## MEMORANDUM

**DATE:** December 21, 2022

**SUBJECT:** On-Call Contract #17-067H-1; PO # 8115428  
Traffic Impact Study Reviews  
Task Order #7: 4-Square at Sterling Ranch East Traffic Technical  
Memorandum - Second Review (PUDSP227)

This memorandum provides a list of comments on the April 2022 4-Square at Sterling Ranch East (SRE) Traffic Technical Memorandum prepared by LSC Transportation Consultants, Inc. for Classic SRJ. Our comments are based on requirements provided in the County's Engineering Criteria Manual (ECM), Appendix B.

Figure 2  
**Site Plan**

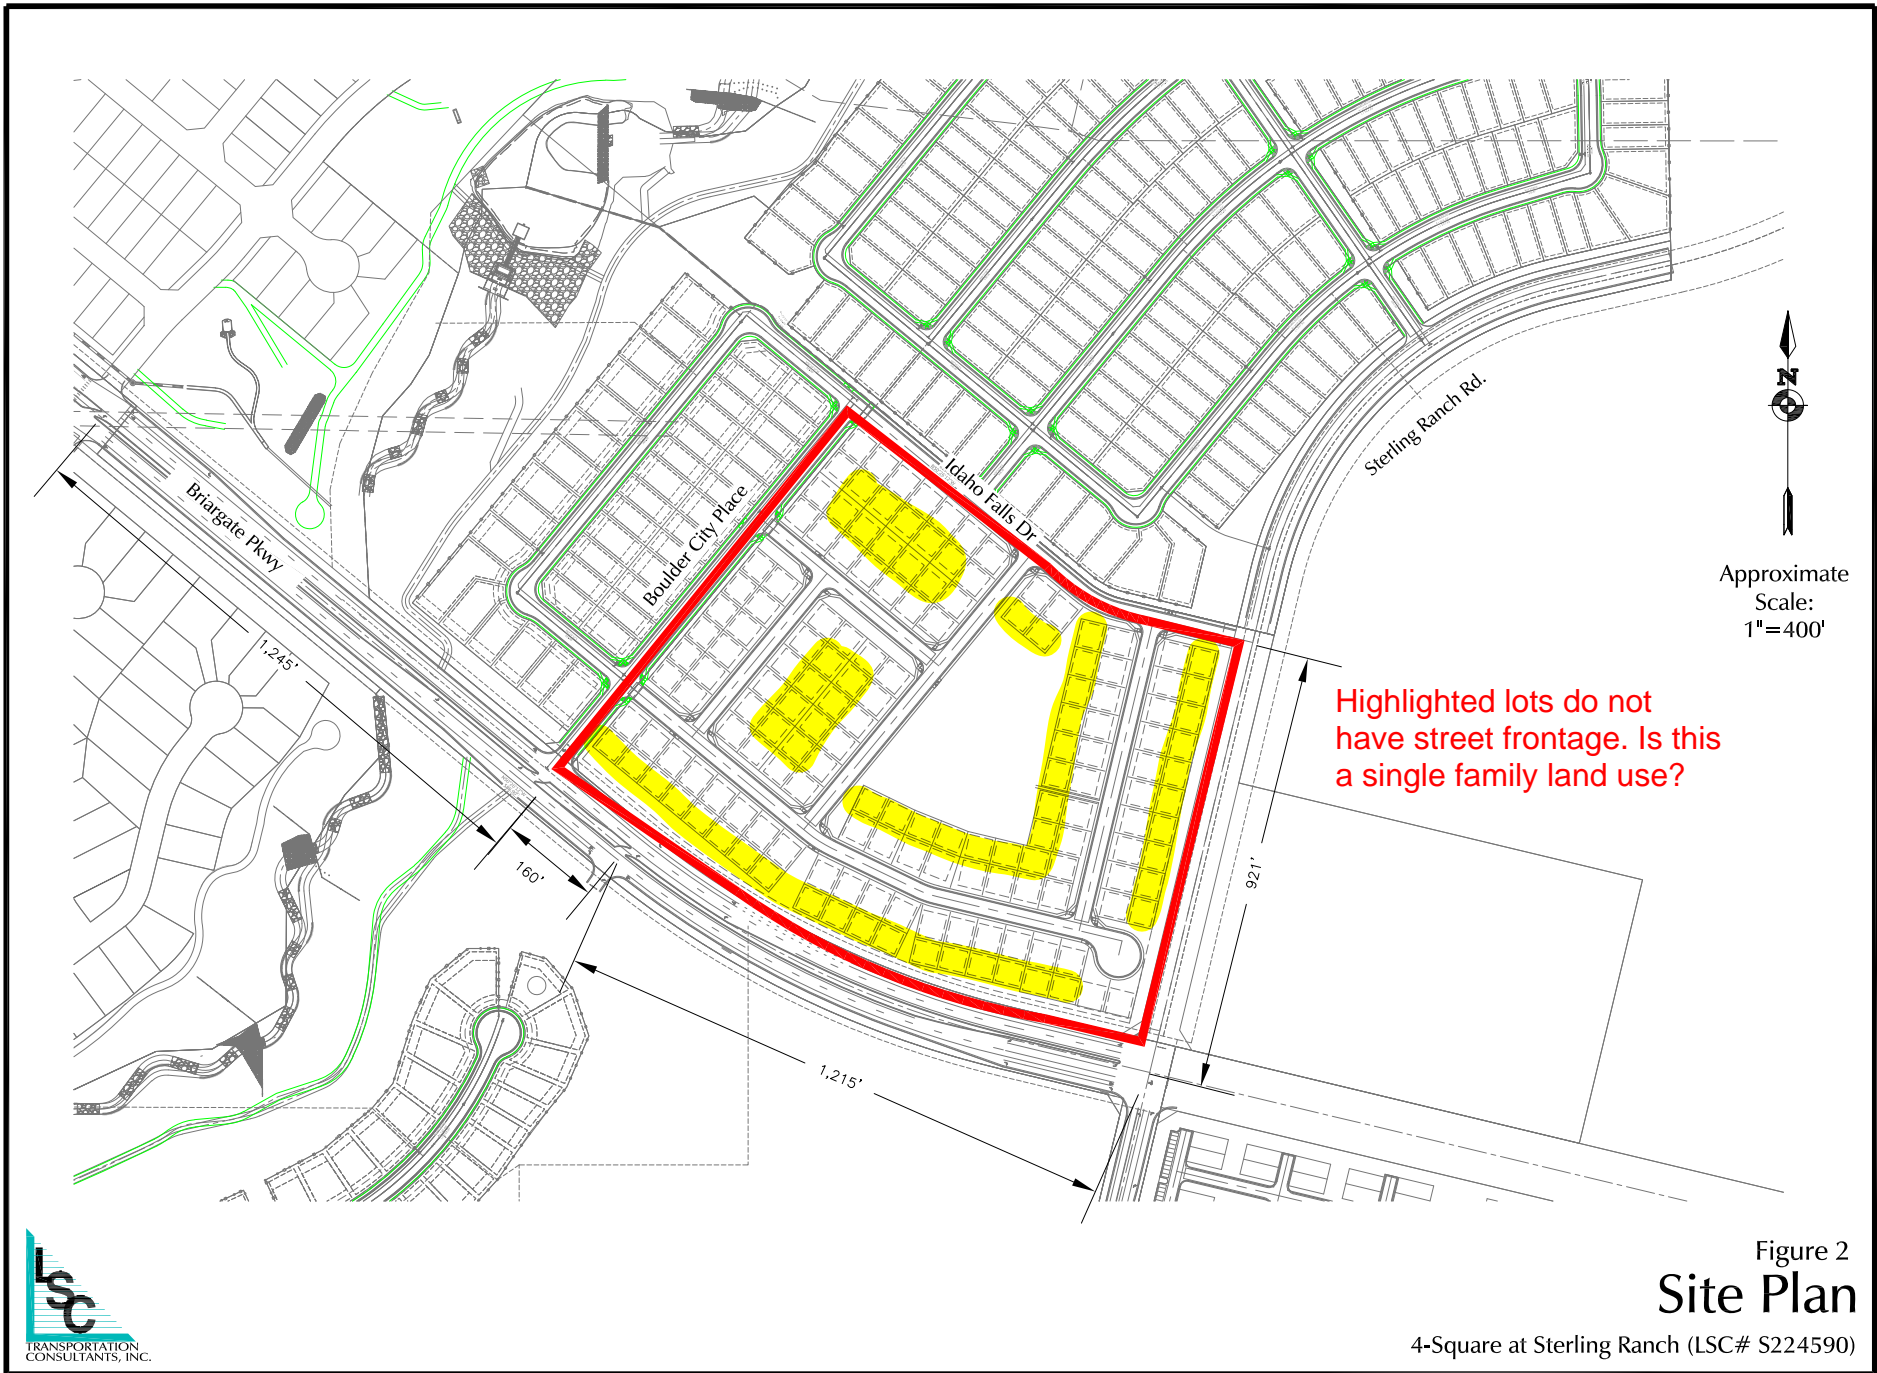
4. The memorandum identifies a single-family residential land use in the 4-Square study area. However, the site plan (Figure 2) shows that approximately half of the study area lots will not have street frontage. This lot layout is more typical of higher-density multi-family residential. The applicant should either select a higher density land use for analysis or justify the use of the single-family land use for what appears to be a higher density development. If the land use type is changed, the update will need to be coordinated with other referenced TISs.

The description for ITE Land Use: 215 Single-Family Attached Housing states that the units share a wall with an adjoining dwelling unit and the description for ITE Land Use: 220 Multifamily Housing states that the units are located within the same building with at least three other dwelling units. The proposed homes within Foursquare at Sterling Ranch East are all proposed to be detached units on individual small lots with no shared walls.

The proposed development is most similar to patio homes which the *Trip Generation Manual* includes as a "specialized land use" under ITE Land Use 210: Single-Family Detached Housing. However, the data is limited to only three sites and ITE intends to provide further analysis in future editions of the *Trip Generation Manual*. Until that further analysis is available, LSC believes that the more conservative trip-generation rates for Single-Family Detached Housing are the most appropriate rates to use for the trip-generation estimate for the proposed Foursquare development.
